From: Graham Nicolls [REDACTED]
Sent: 13 January 2020 18:48
To: David Spring <David.Spring@arun.gov.uk>
Subject: RE: LU/328/19/PL -52 HIGH ST LITTLEHAMPTON

Dear David, RE: LU/358/19/PL I see on the website that there is an objection from The Environment Agency supported by Littlehampton Town Council regarding the change of the Bedroom in the rear cottage to the Ground Floor.

SCALE / 1:100 @ A3
 DATE / 28.02.2019
 DWG.NO/ 011219/TP.02 REV'B'

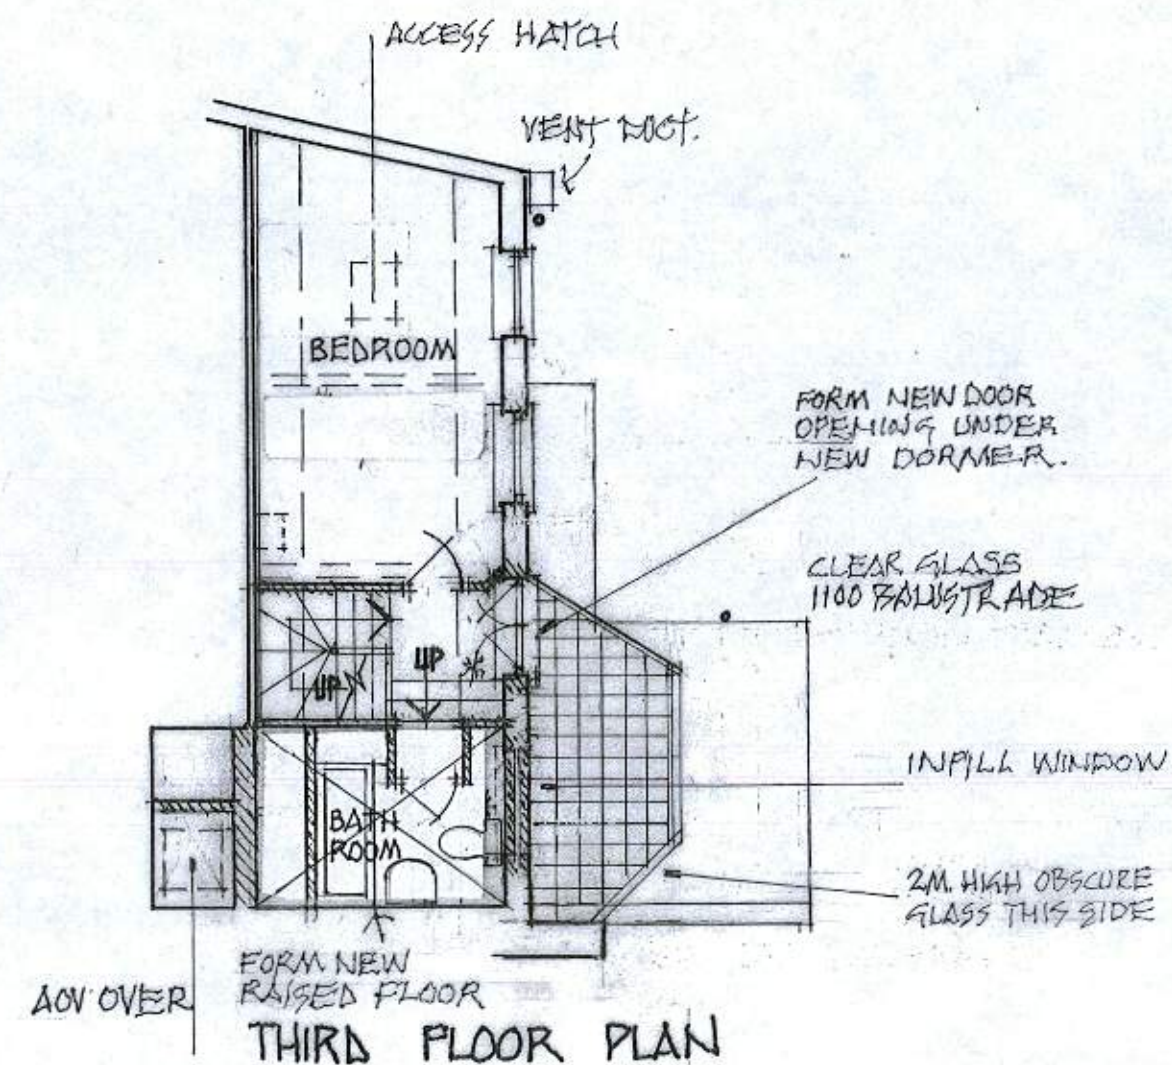
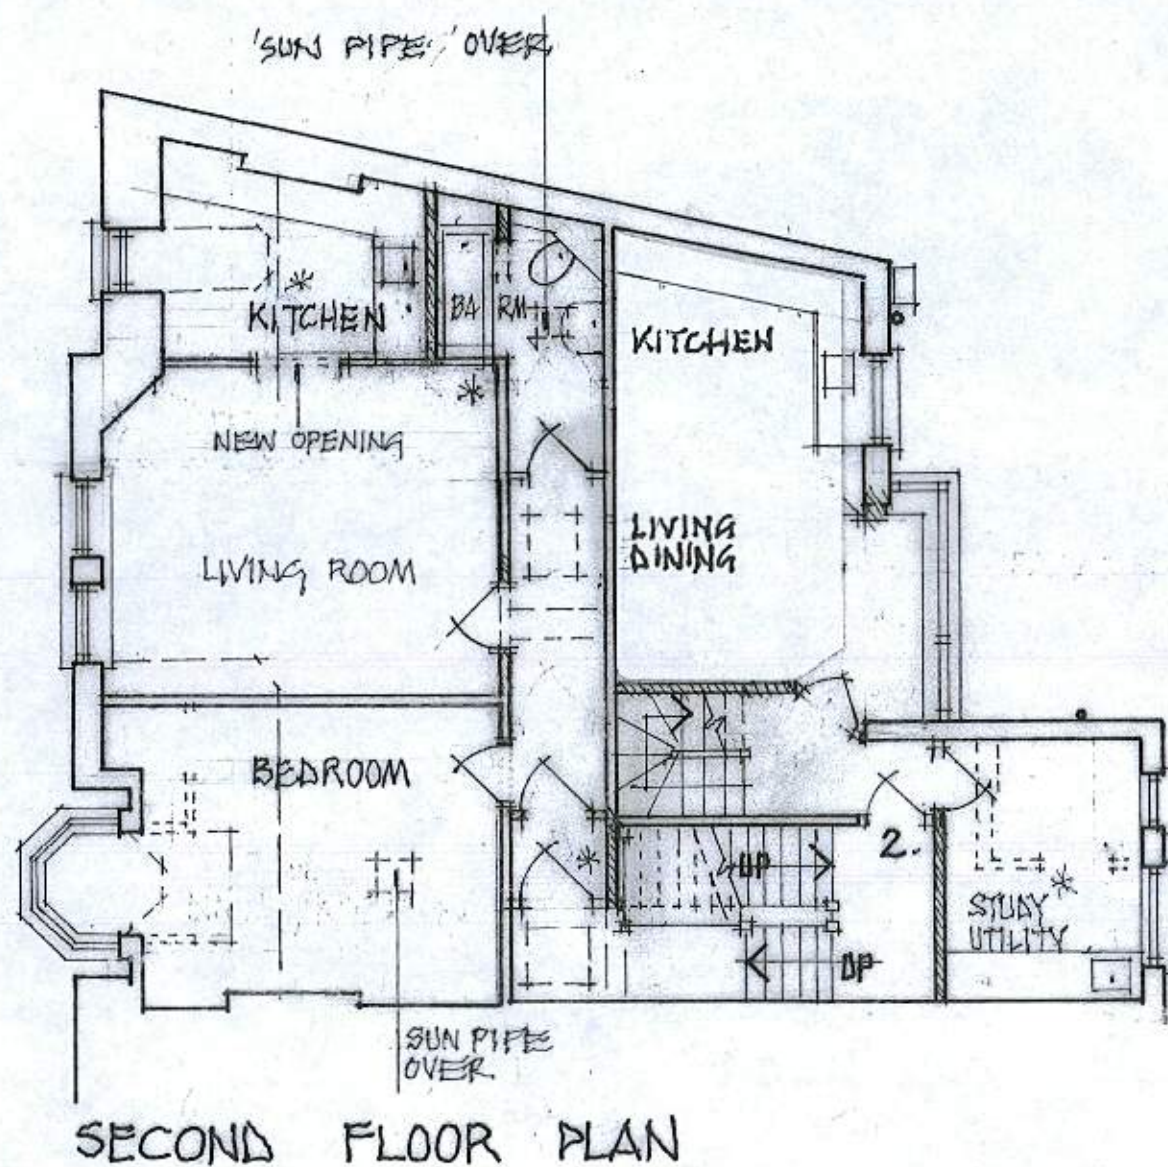
Yes this would be very helpful. I'm just back today but I was going to ask you this as apart from the Env. Agency objection the current proposal would also be in contravention of the original condition 3 which required bedrooms to be on the 1st floor or higher.

I will amend the relevant drawings relocating the bedroom to the First Floor as previously approved and put the Living area back on the Ground Floor.
